CITY OF ALBUQUERQUE

**Re: Andalucia Villas, Tract 4 and 6 North Andalucia
Grading and Drainage Plan
Engineer's Stamp Date 6/04/2012 (E12/D015C)**

Based upon the information provided in your submittal received 8/07/2012, the above referenced submittal can not be approved for Building Permit Approval until the following comments have been addressed:

SHEET CONTENTS:
PROPOSED DRAINAGE
MANAGEMENT PLAN
SHEET NO.
C1
10350

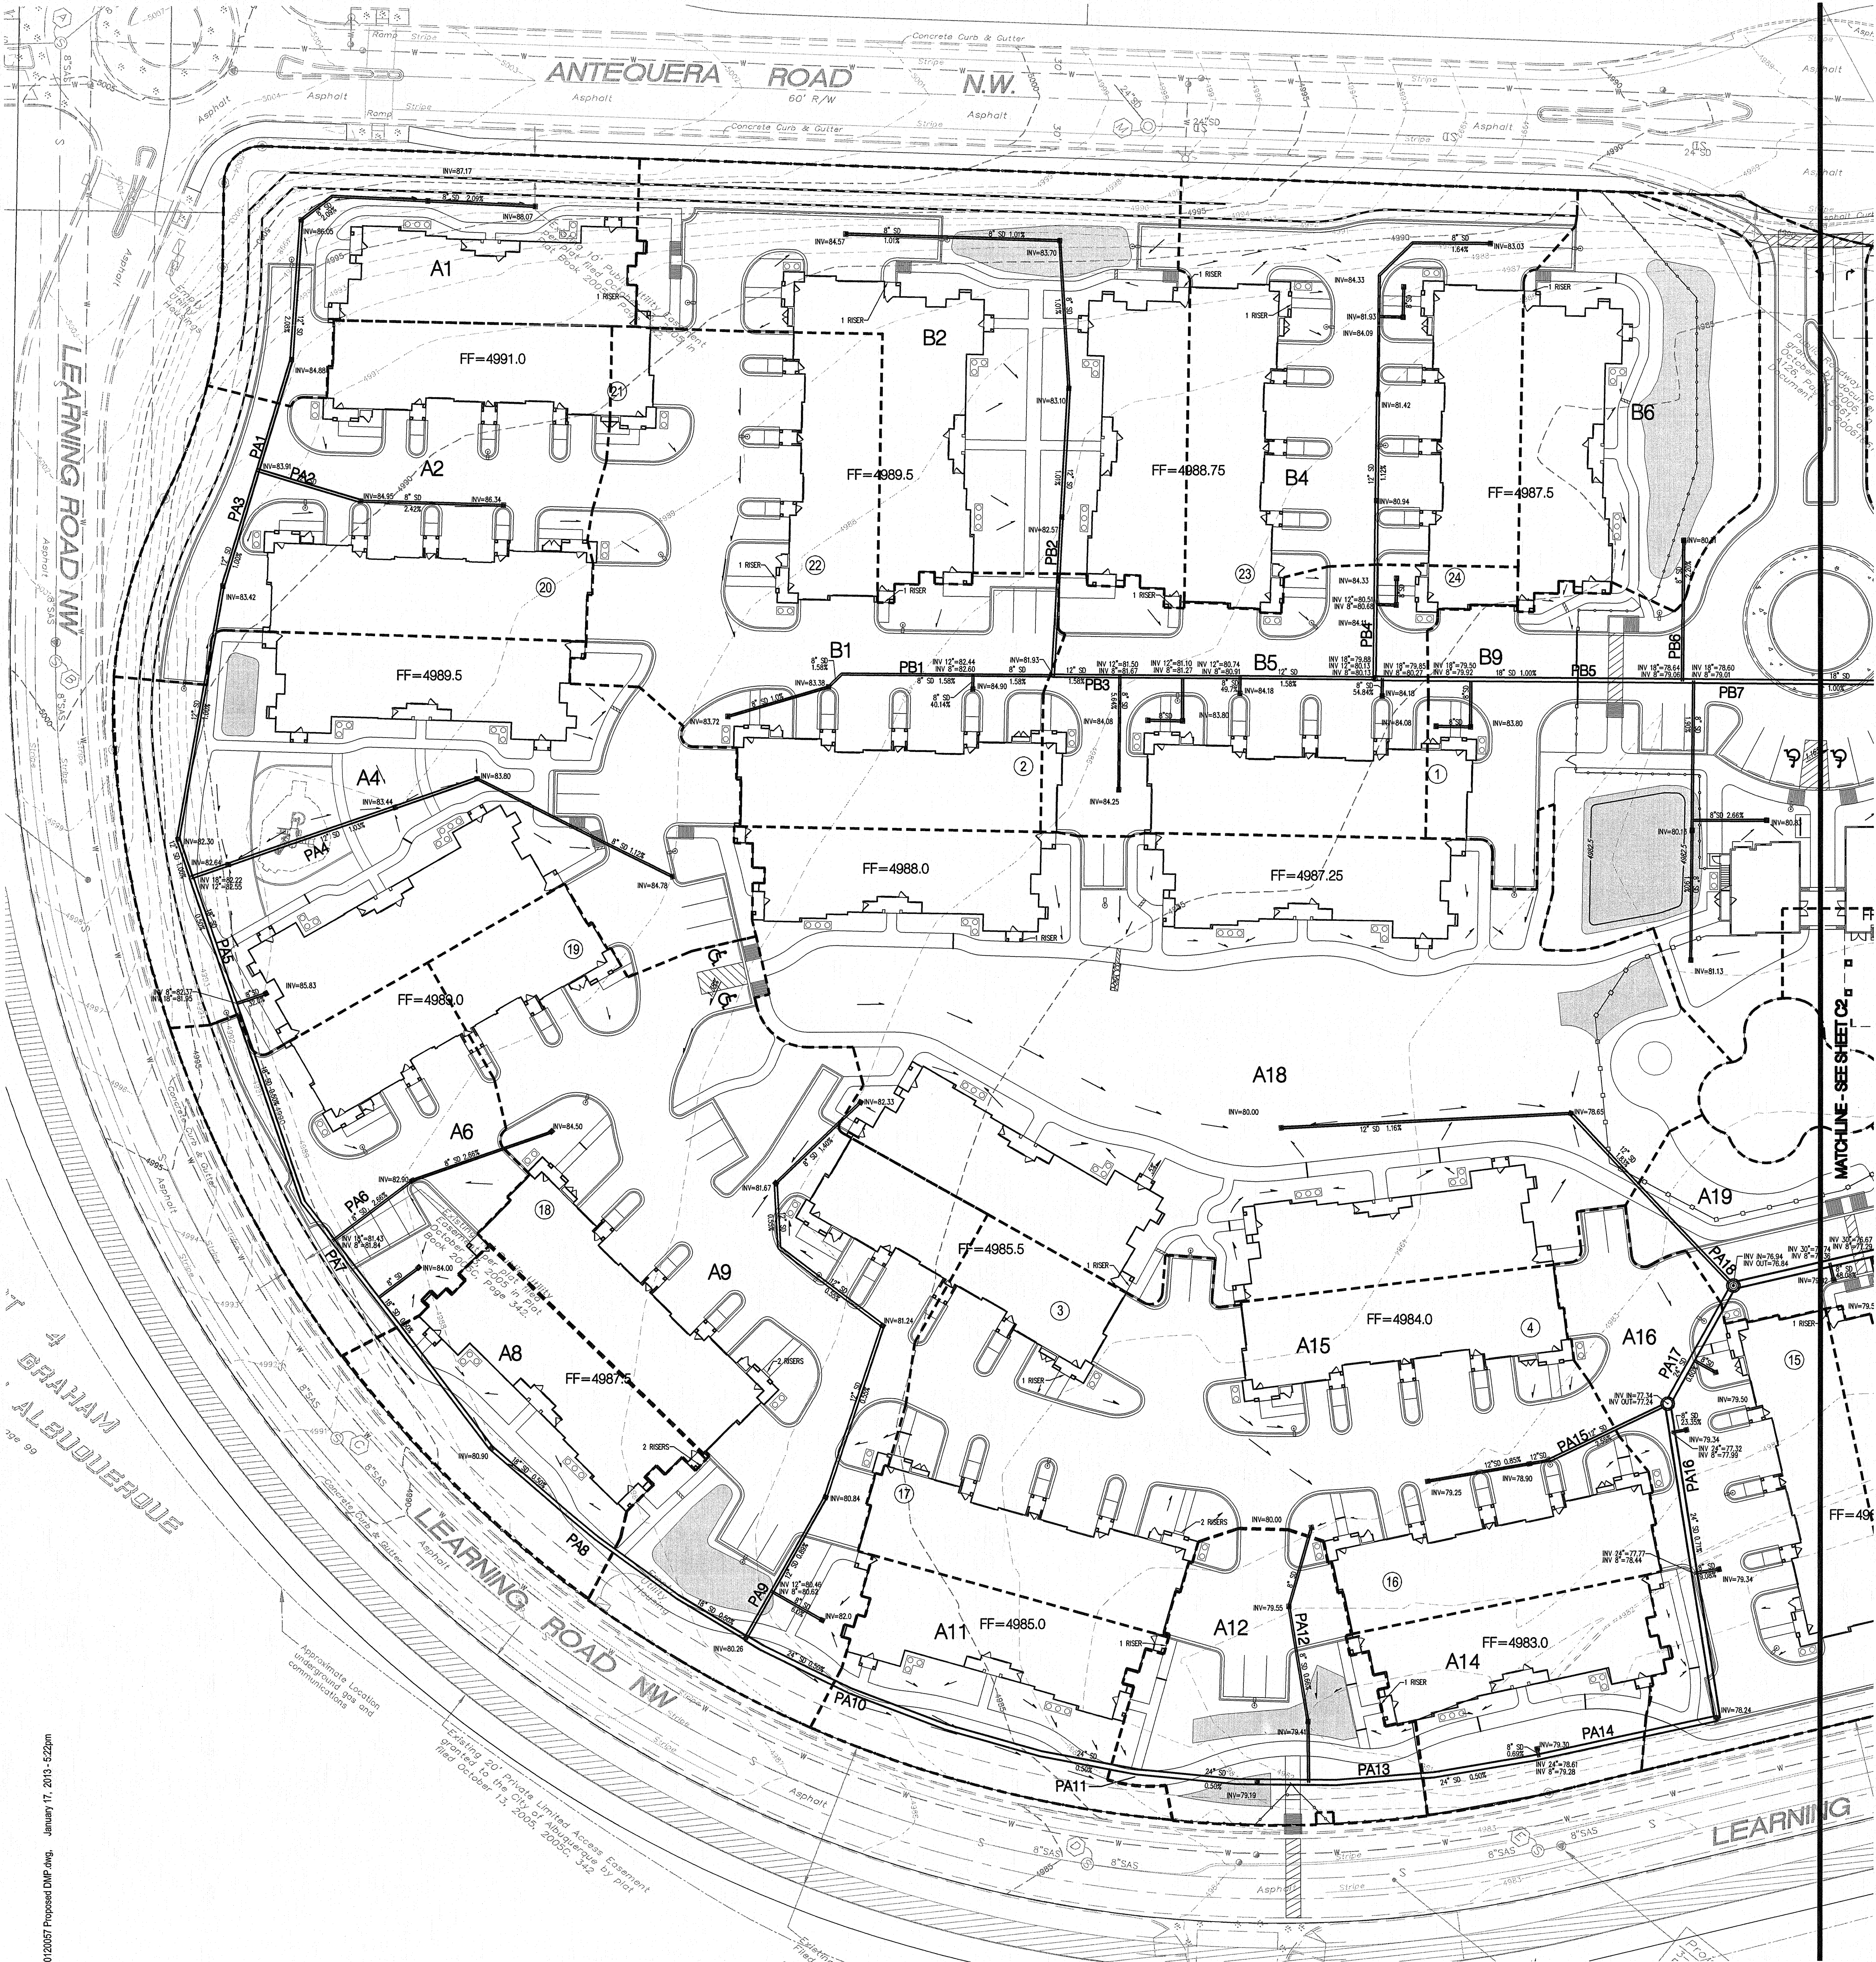
- Include the 100-yr/10-day Volume calculations on Sheet C1.
- Provide sections at the highest point of the retaining walls where retaining walls are being proposed. Please include the garden wall. The total height (retaining wall + garden wall) can not exceed eight feet.

Antequera Road Capacity Analysis

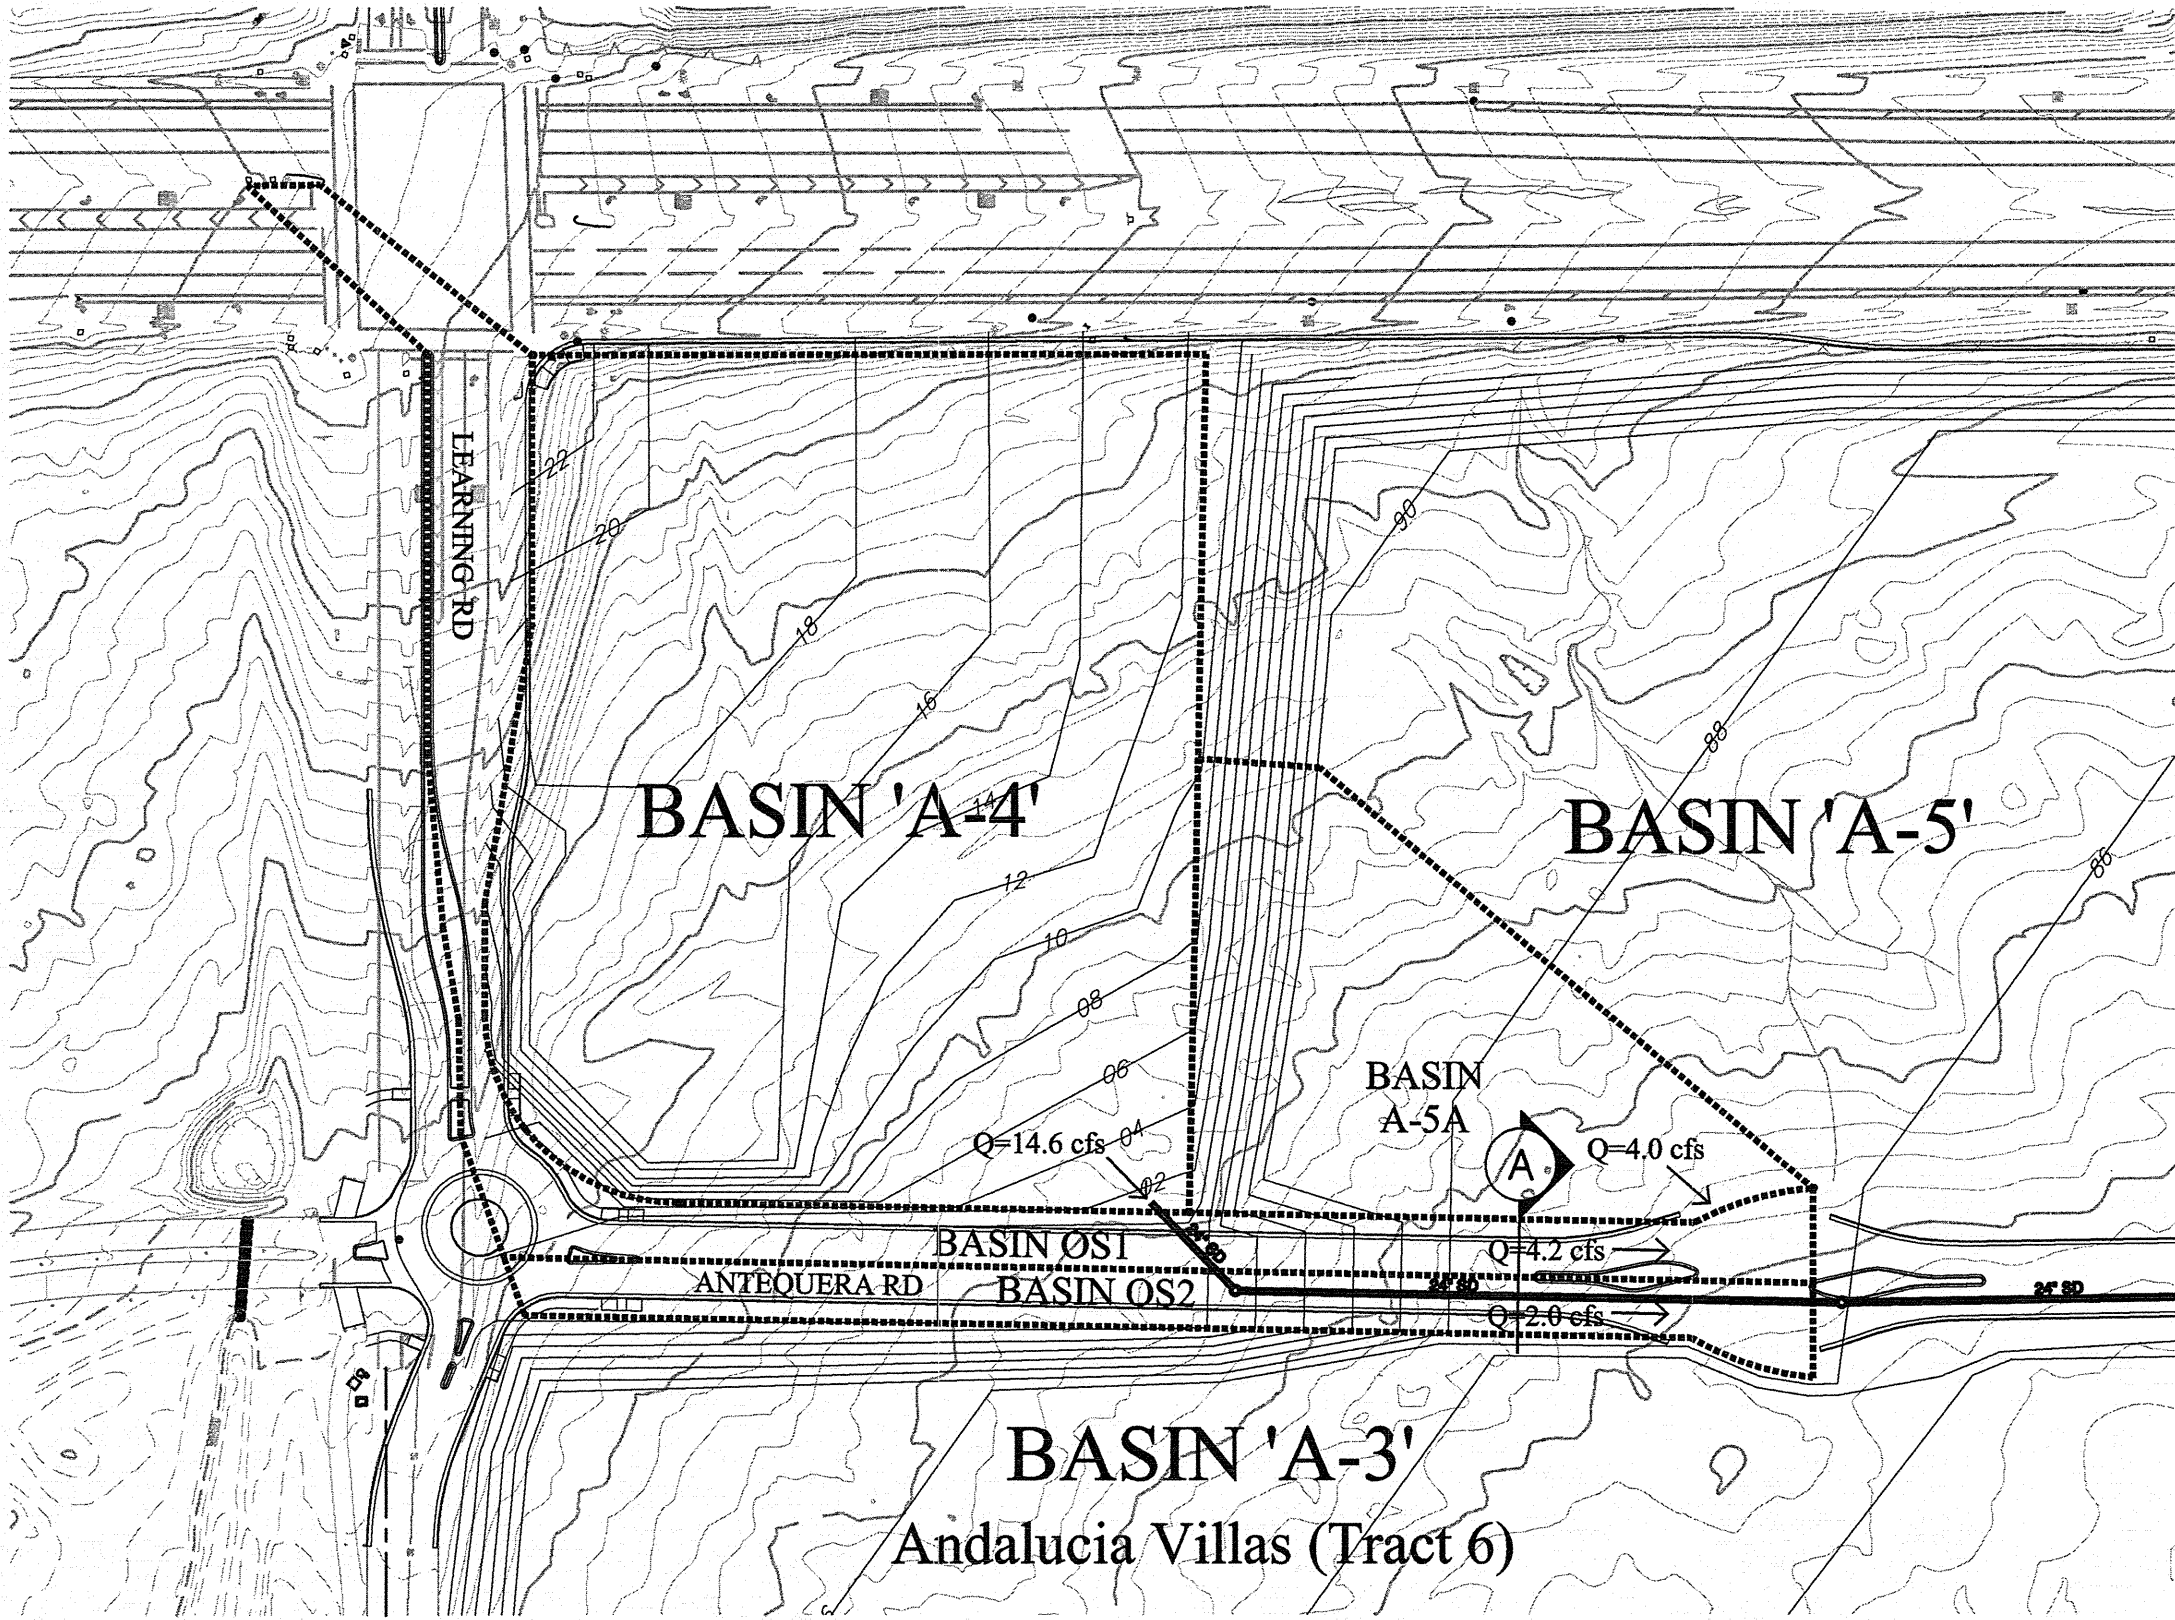
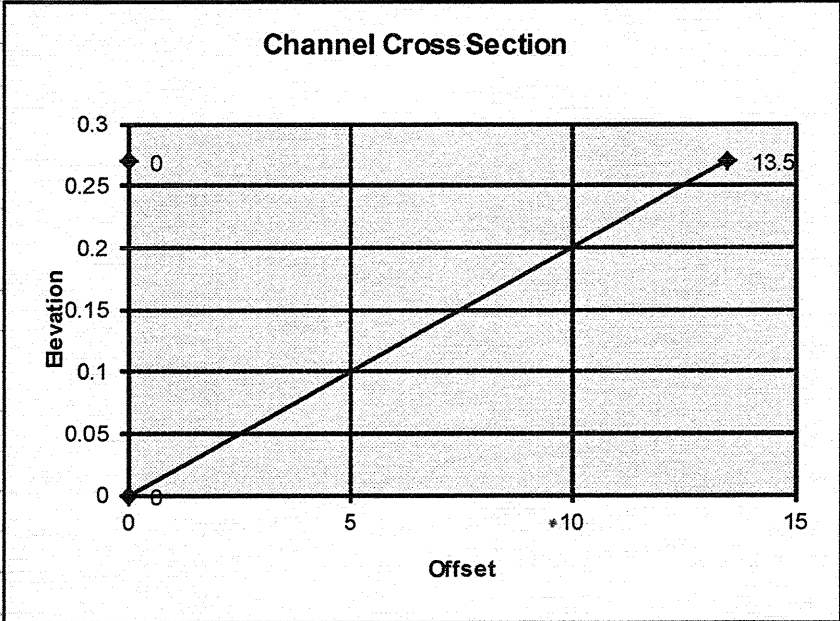
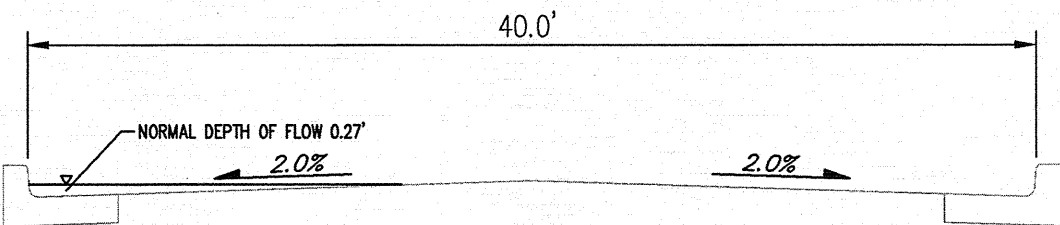
- What is the runoff depth in the street by the entrance on Antequera Rd.? The runoff might be jumping the handicap ramp and over the sidewalk on the east side of the entrance.
